EAST PYE SOLAR

WRITTEN REPRESENTATION

Planning Inspectorate Reference: EN0110014

Interested Party	Christopher Humphrey
Property	[REDACTED]
Relevant part of Scheme	Site 5 / proposed 400kV substation and associated infrastructure
Submission	Written Representation - Deadline 1
Interested Party reference	F83984C72

1:25,000 @ A3	Date: 18/02/2026
Drawn: MB	Checked: AC
Figure: 6.2.7.10	Rev: V1

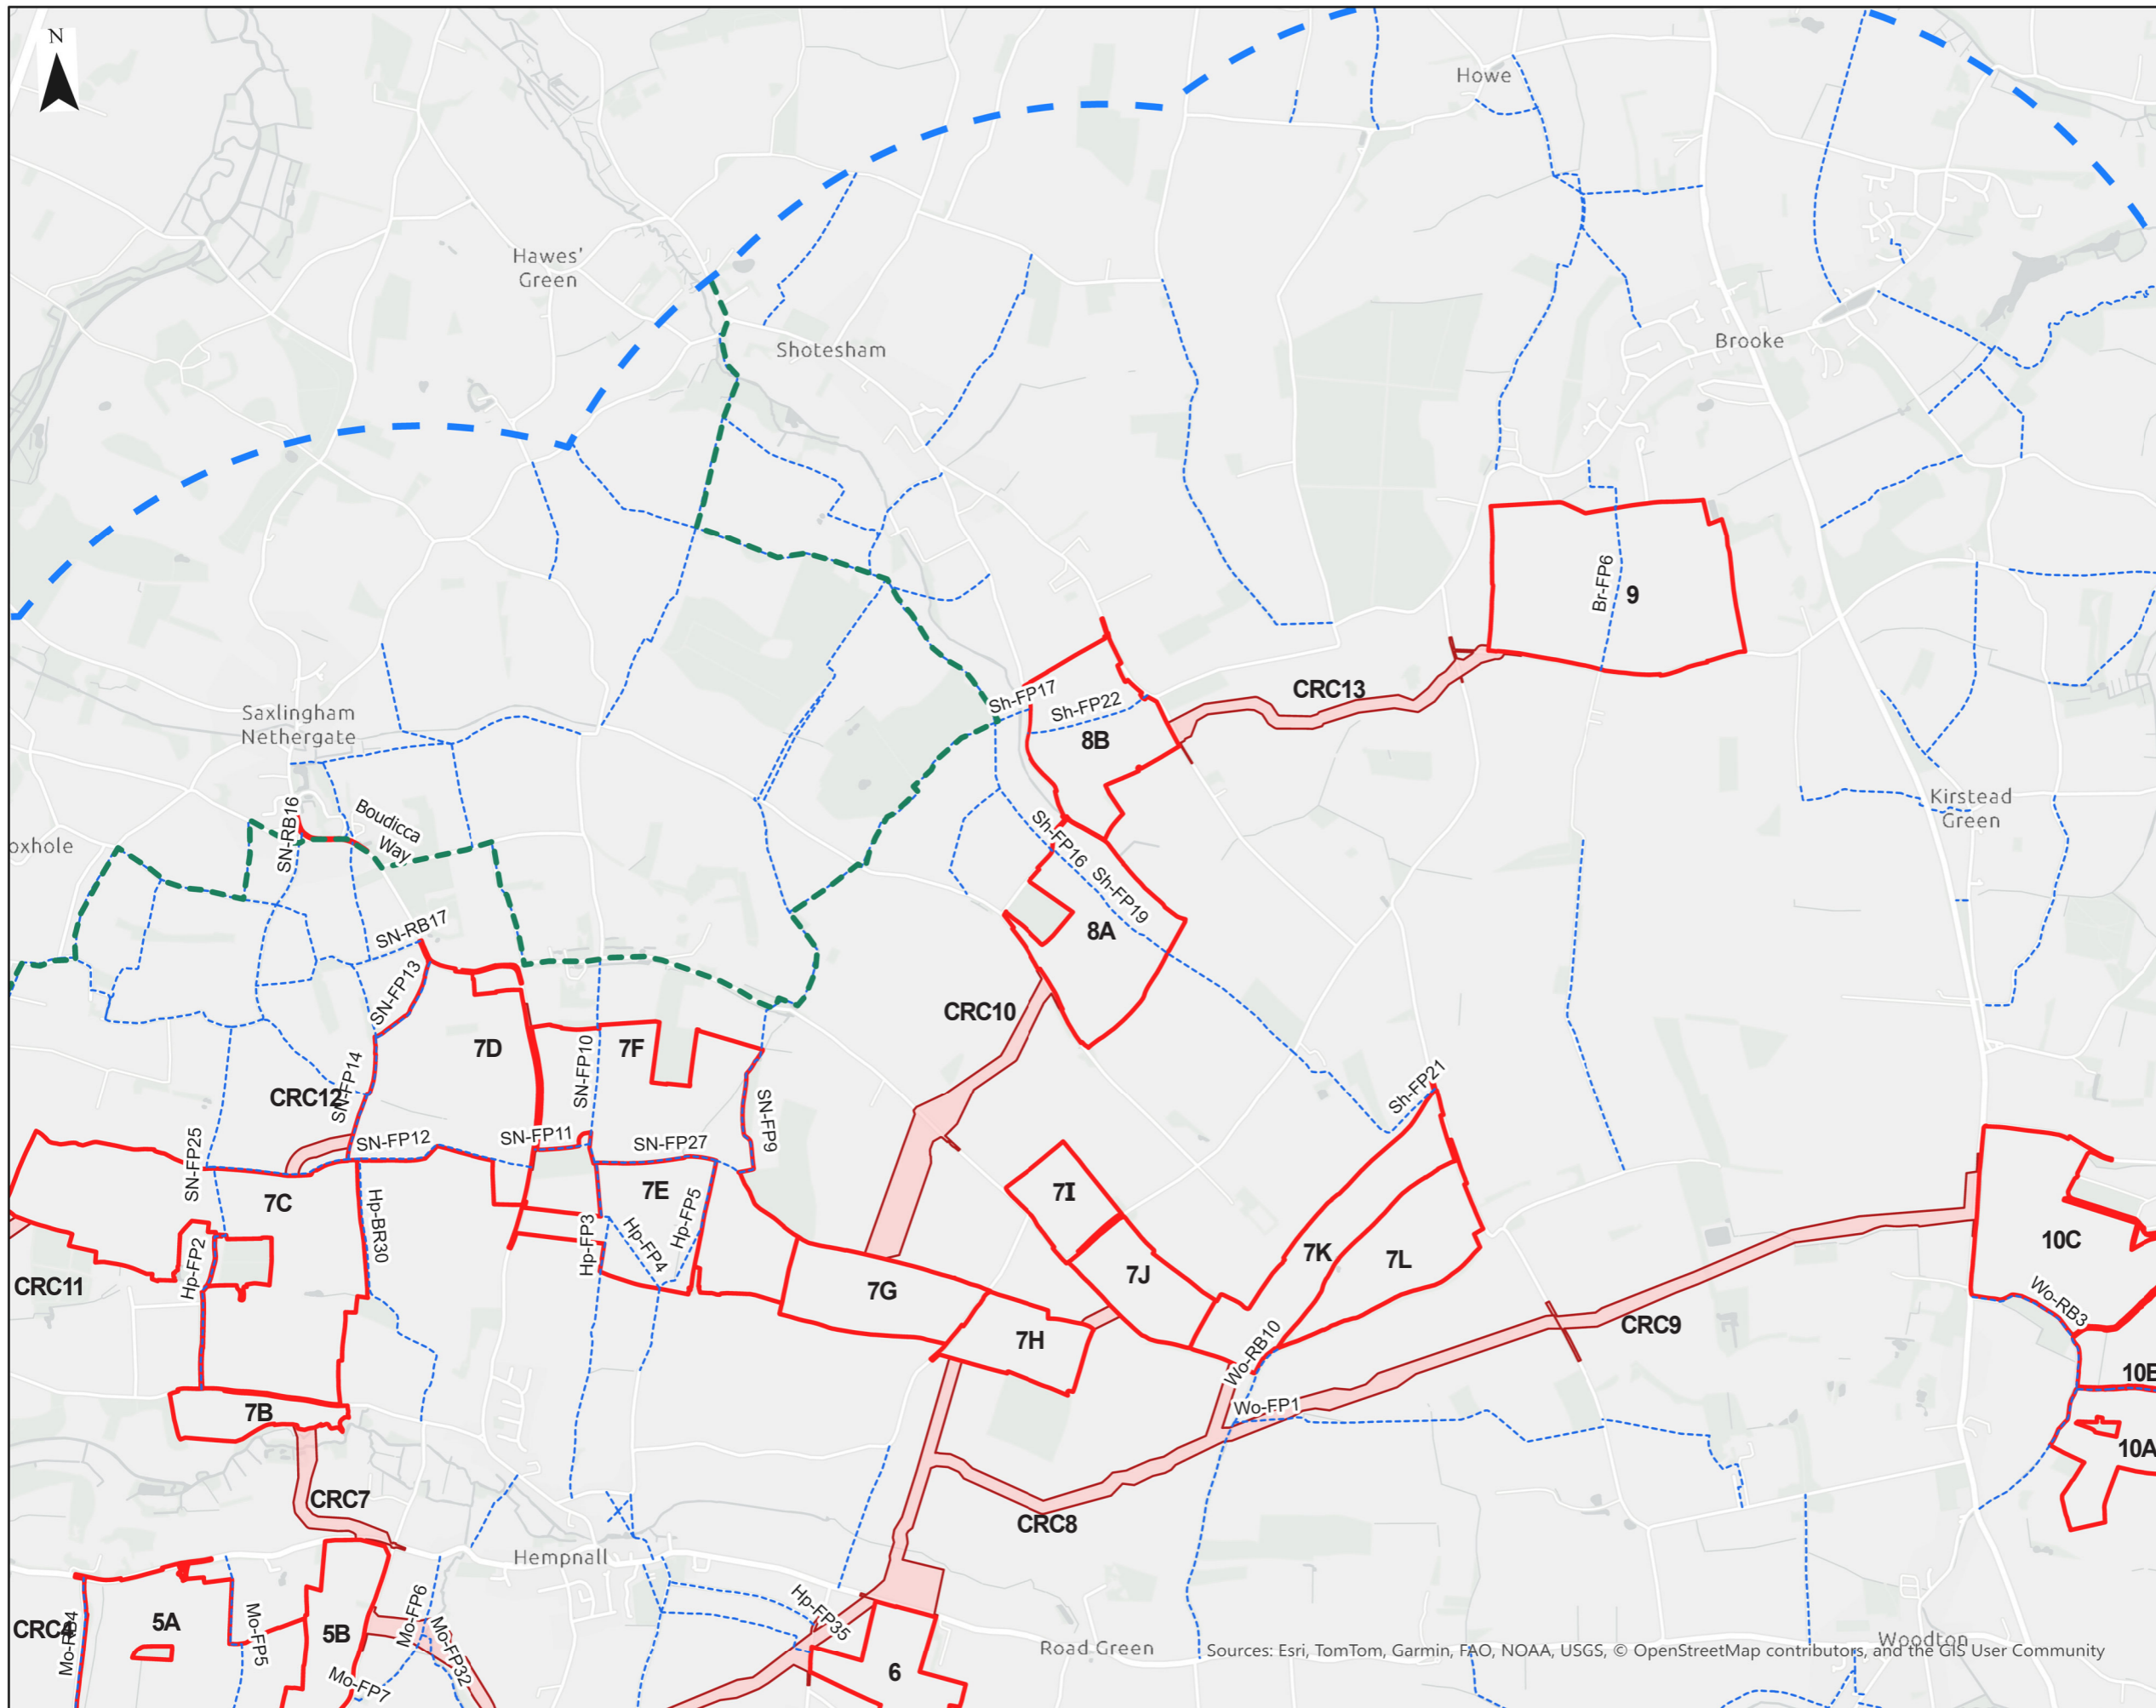
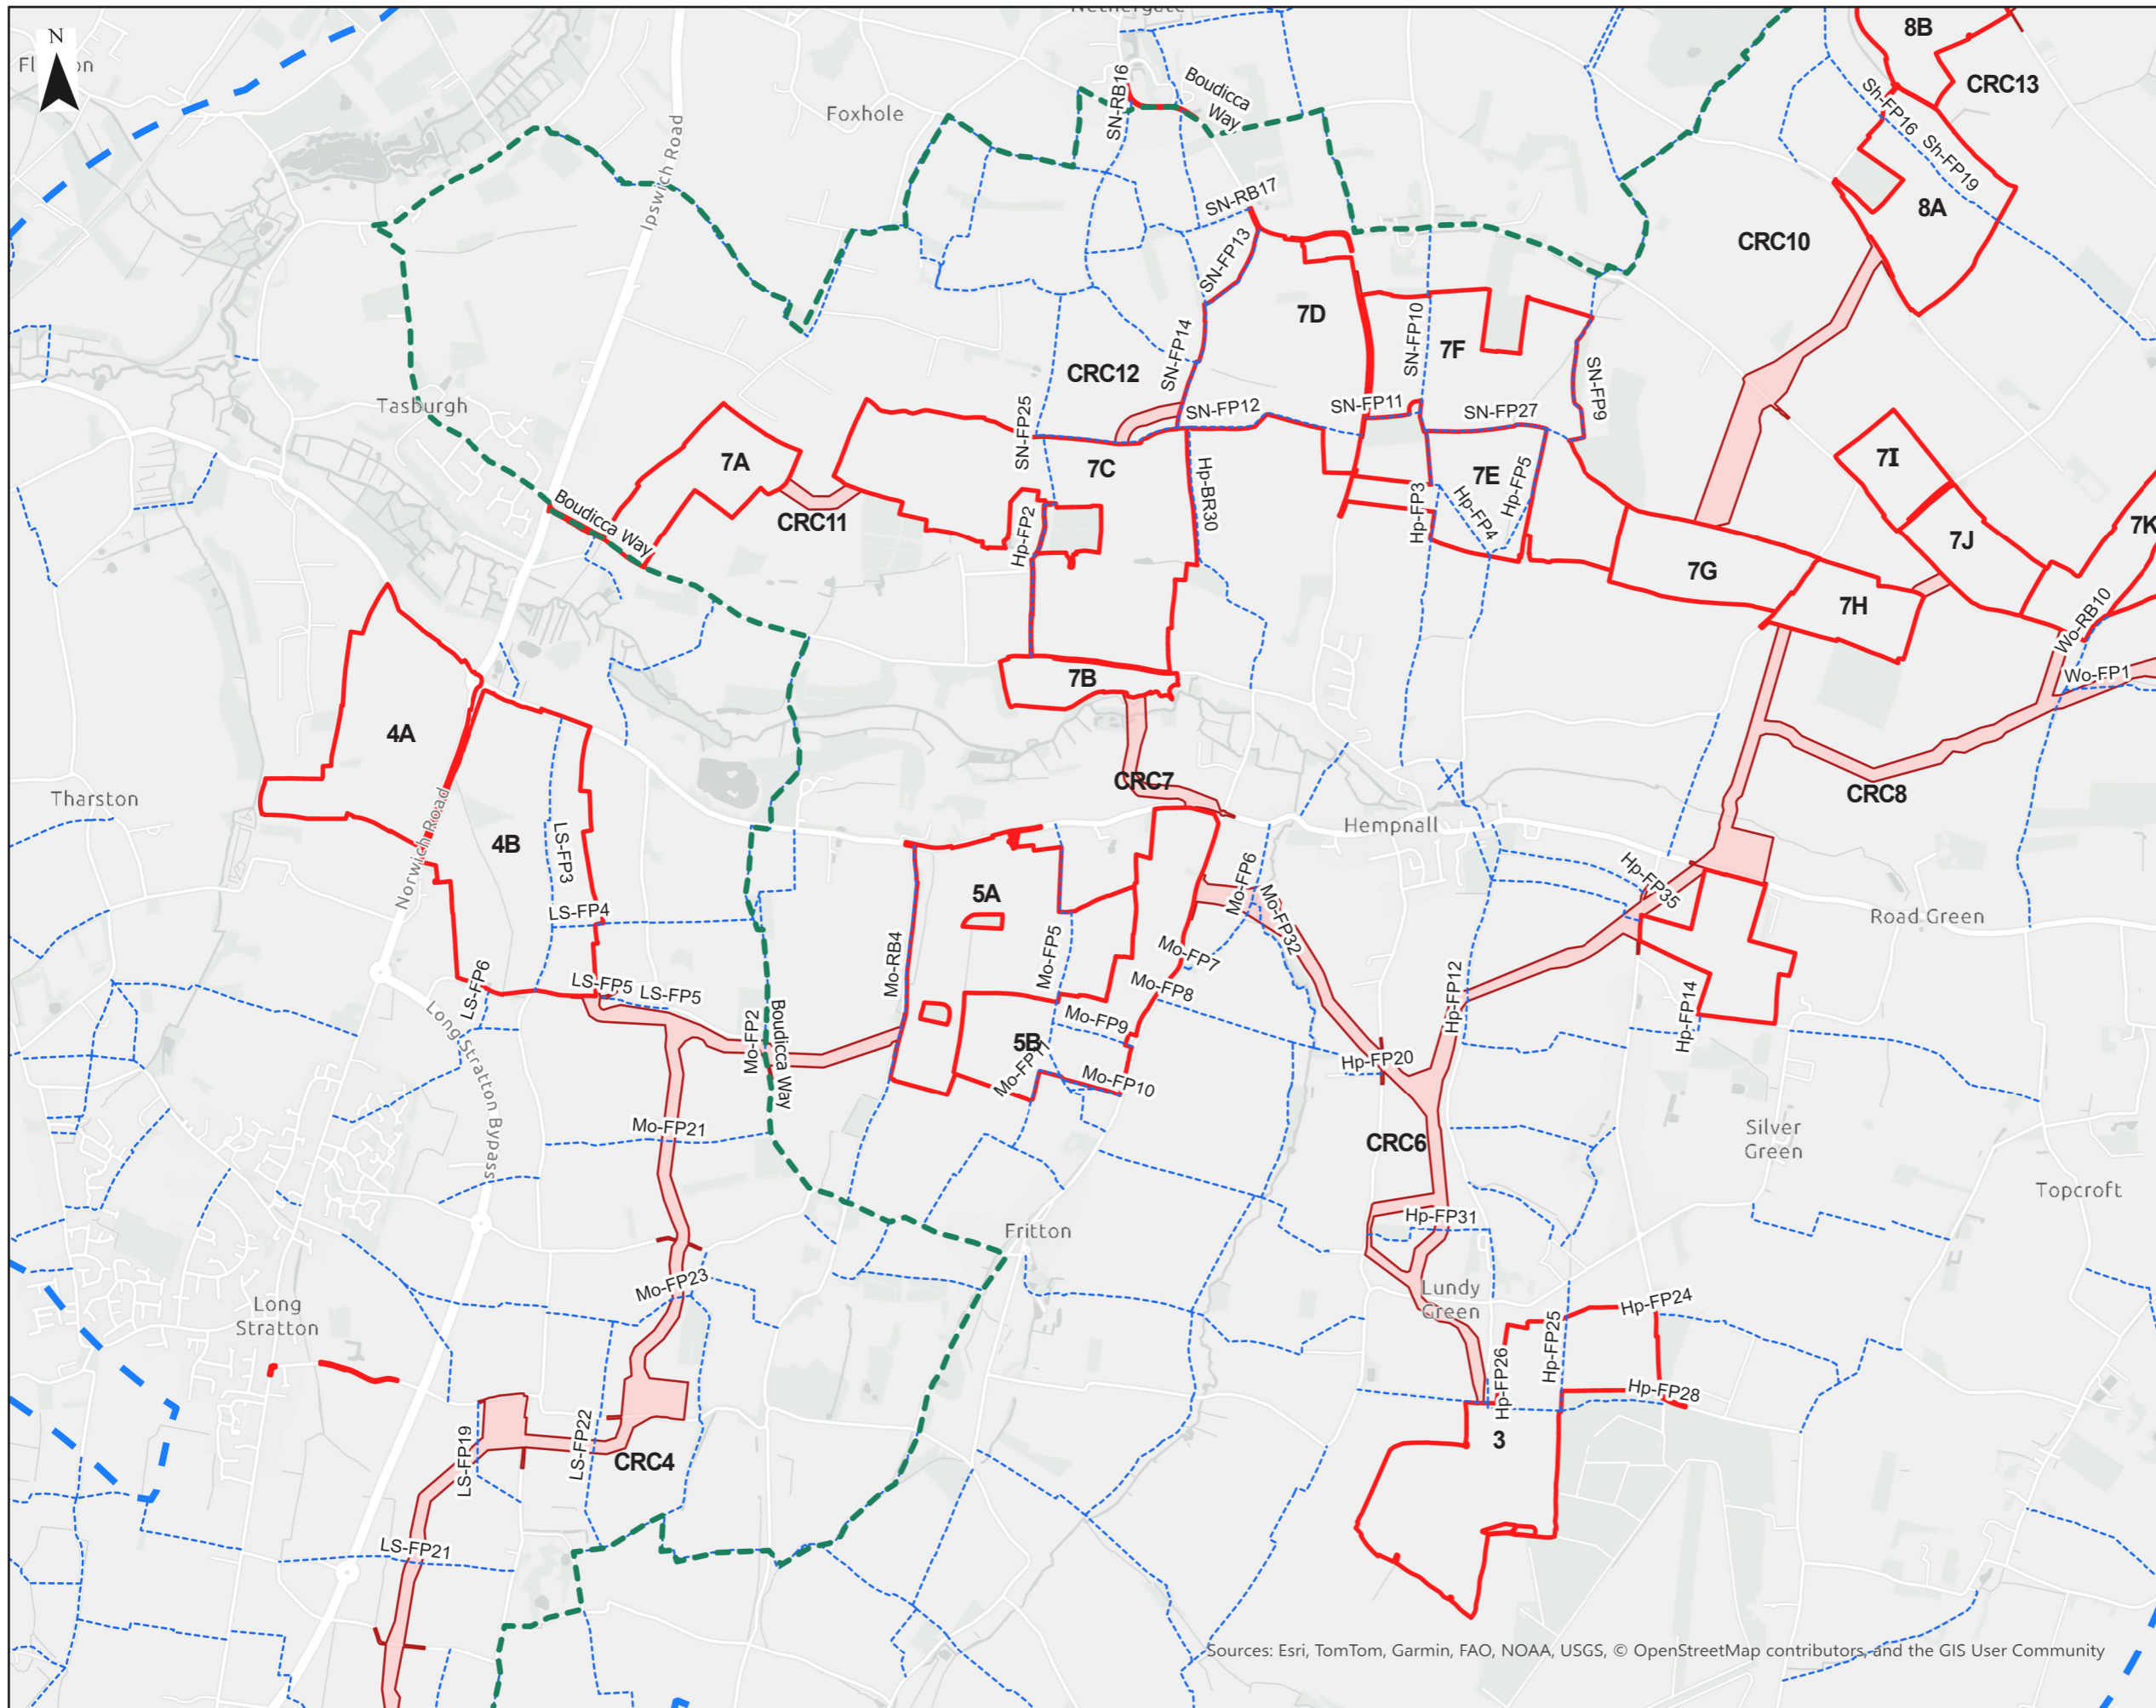
I therefore ask that the Applicant confirms how the effects on users of the relevant footpath have been assessed in the vicinity of [REDACTED] and the Site 5 Project Substation/access track, and how safe and convenient use of the route will be maintained during construction, operation, maintenance and periodic replacement activity. Particular attention should be given to locations where the operational track runs alongside or intersects the PRow.
